Pres Center on Louisiana

Administrative Amendment Request

Project #PR 2018-001579 SI-

Transportation Development Comments:

COMPOSITE-AS-BUILT SITE PLAN  
 SP-1

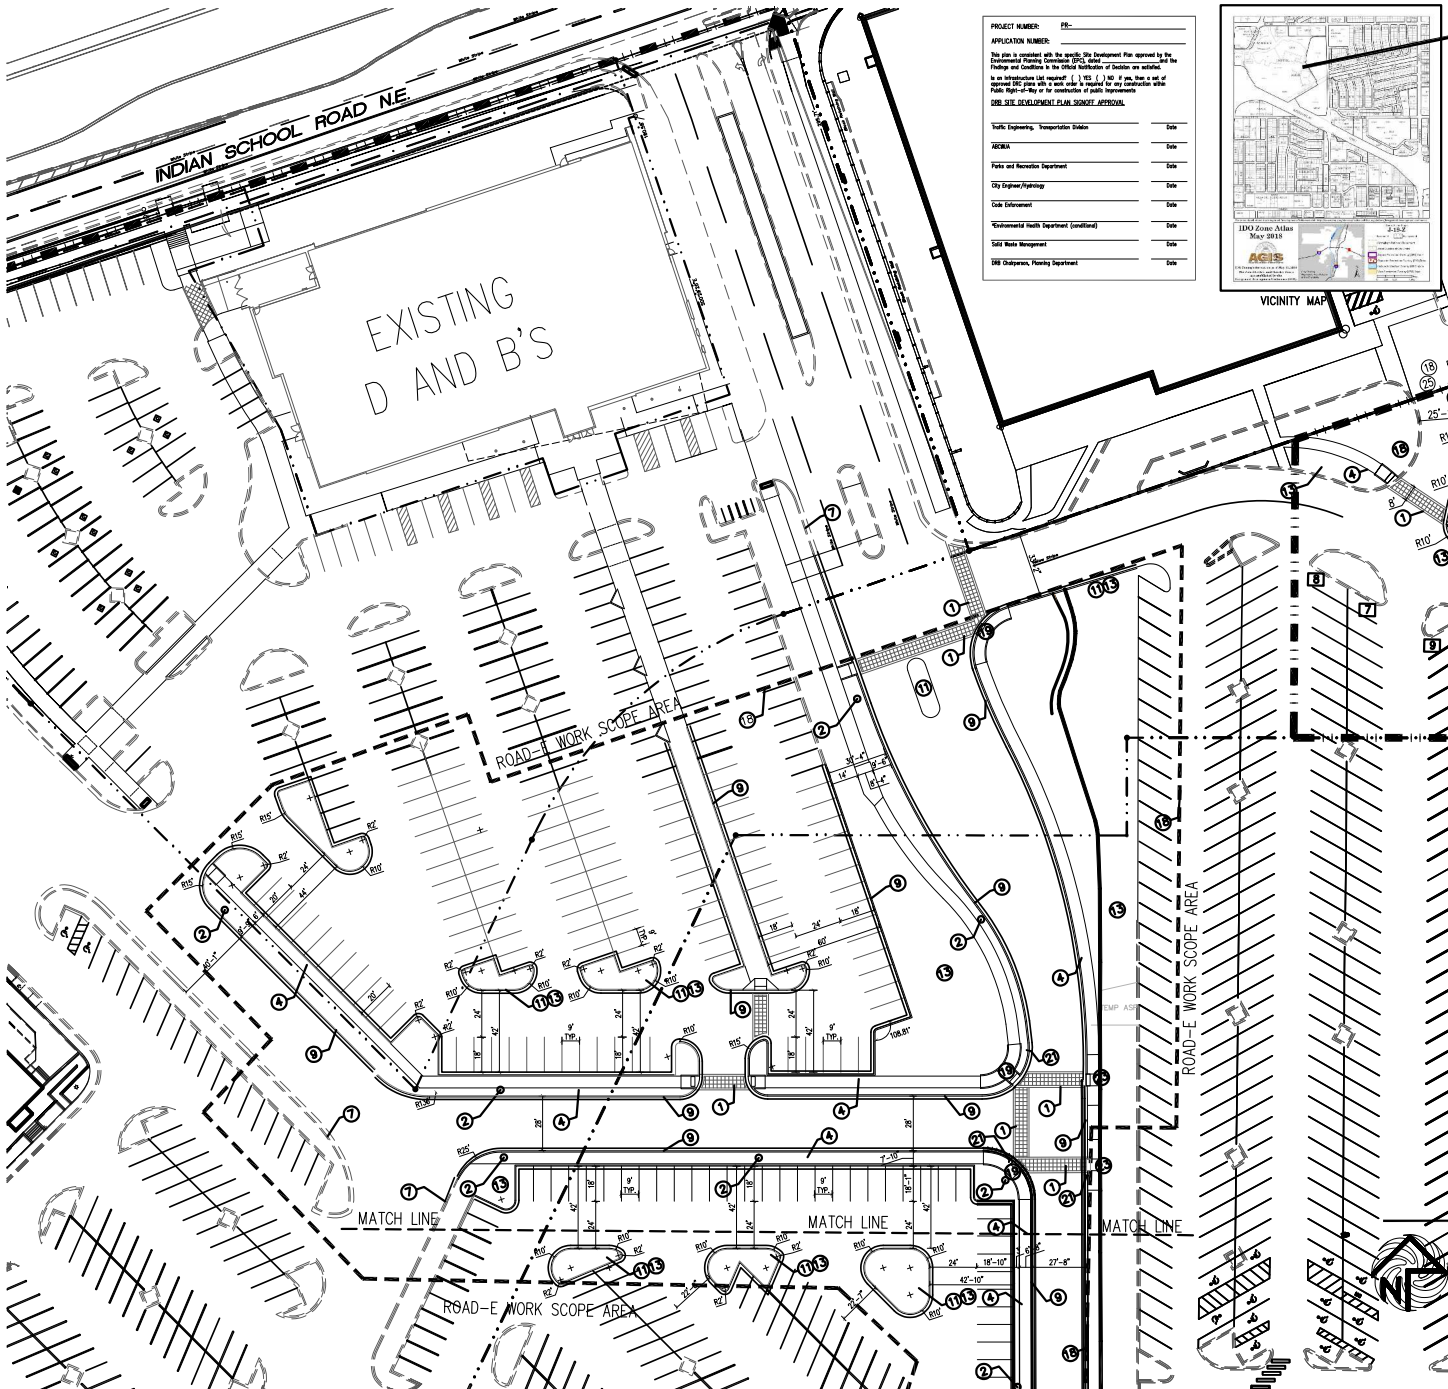
- New wall on north side appears to affect existing 6-foot sidewalk. Provide detail and sufficient space that includes the sidewalk, wall, and **a cross section has been included with the revised drawings.**

- Show sight distance triangles at the driveway entrances and add the standard note regarding no placement of obstacles between 3 feet and 8 feet high within the clear sight triangle. Include this on both the site plan and the landscaping plan. **Triangles and note have been added.**

- On the southwest corner of the site at the end of the parking aisle, include the generator and the other item labeled "T" in the legend. Is access adequate at these locations with the length of parking spaces? Clarify. **Clearance requirements for access are now shown on the plan. The parking spaces do not impede the required access clearances.**

- Identify dimensioning for ambulance loading area to verify its adequacy. Detail this area. **Dimensions and additional detail has been shown on the plan.**

- Show 2% maximum cross-slope for the sidewalk detail. **This detail/note has been added.**
- Label curb height for landscaping islands at 6" or 8" and provide detail. **The curb height has been labeled and detail added.**

- Label all curb radii and parking aisle widths. Show width of all handicapped spaces and handicapped aisles on the site plan. **These dimensions have been added.**

- Show motorcycle parking on the site plan and dimensioning for parking spaces. **The motorcycle spaces and dimensions are now shown on the plan.**
- Call out any signage (handicapped and motorcycle parking) with keyed notes on the plans. **Signage has been called out and details added.**
